28 June 2021

Pamela Morales  
Principal Planner  
Industry Assessments  
Department of Planning, Industry & Environment

**RE: Mayfield West Waste Facility-Mod-1 (SSD-7698-Mod-1)**  
**Request for Additional Information**

In response to your RFI letter (08/06/2021), please find below further information addressing the Department's issues as well as additional issues raised by Council and the EPA.

Figure 1

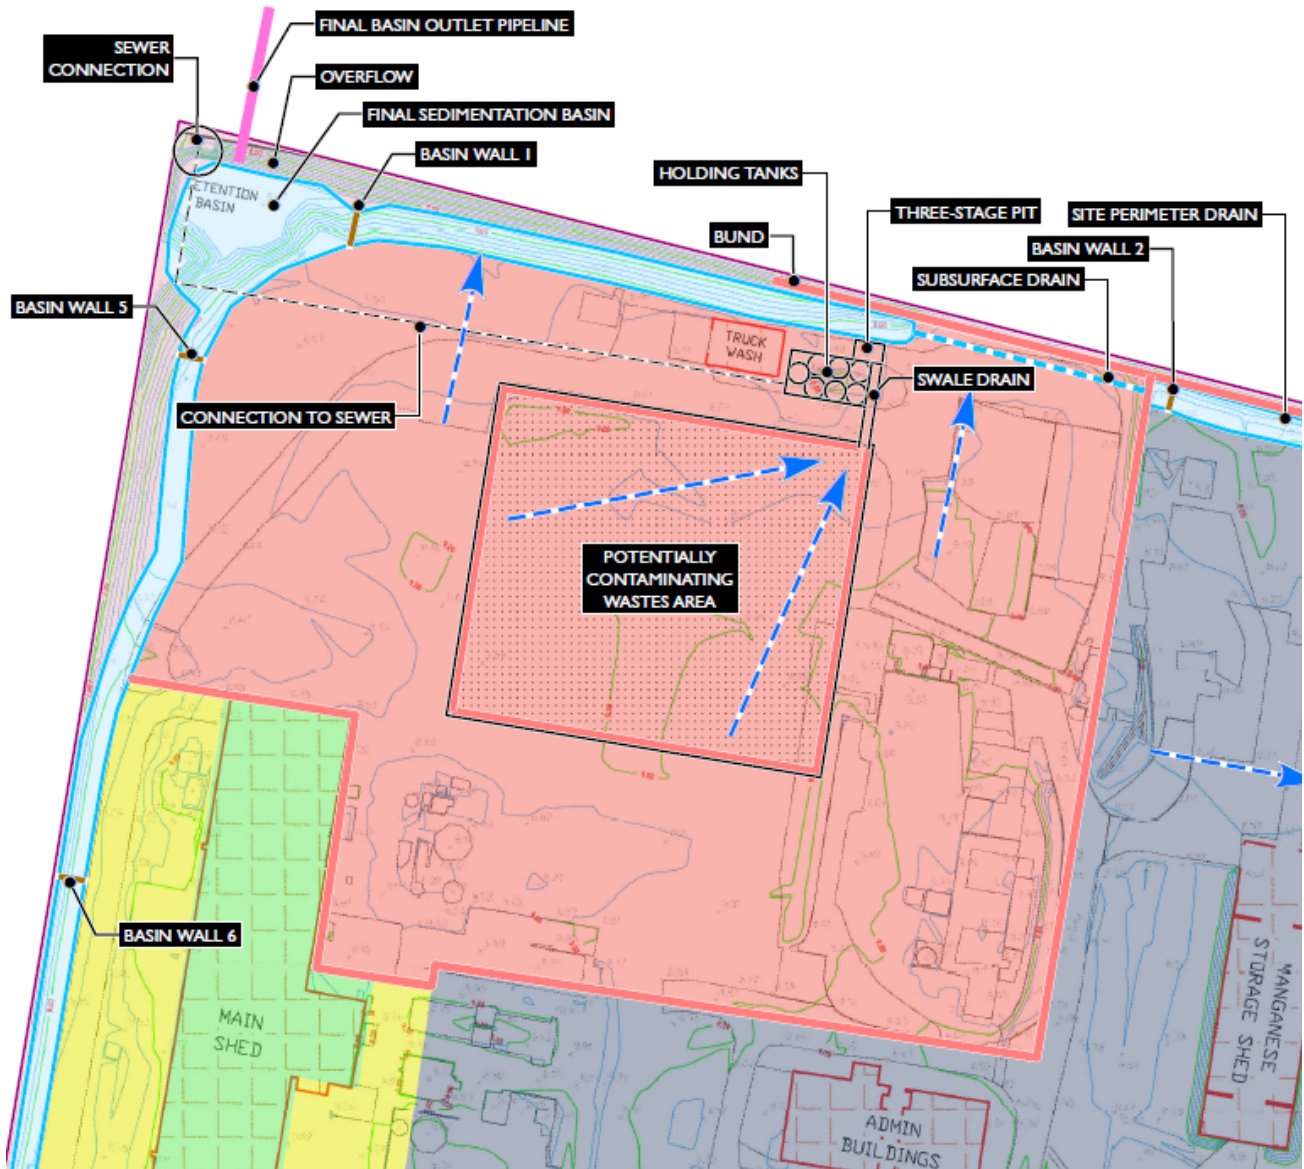
**-Figure 8 shows the existing water management system for Area 1 and 2 only. The new proposed Areas would be within the Area 3 catchment in the soil and water management report. Please update the existing soil and water management report to include the new areas proposed for inclusion within the site boundary for SSD 7698.**

The facility's water management system receives surface water runoff from Lot 1 DP874109, which has a total area of approximately 7.9 ha. The materials handling portion of the existing recycling facility is operated in the western portion of the lot, within a 3.7 ha area. The remaining 4.2 ha of the lot is used for ancillary activities approved under Newcastle City Council Development Application DA2015/0291 and includes buildings, storage of empty customer bins and laydown areas. Figure 1 shows the layout of the stormwater system.

The proposed 0.4 ha increase in the area of the recycling facility will not change the stormwater system in any way as:

- Runoff from this area currently drains to the existing stormwater system (i.e. the Area 2 water management system will still have a 7.4 ha contributing catchment area – see Figure 1); and

- All general solid waste that is considered to have a higher risk of contaminating stormwater will continue to be stockpiled in Area 1 (see Figure 1)
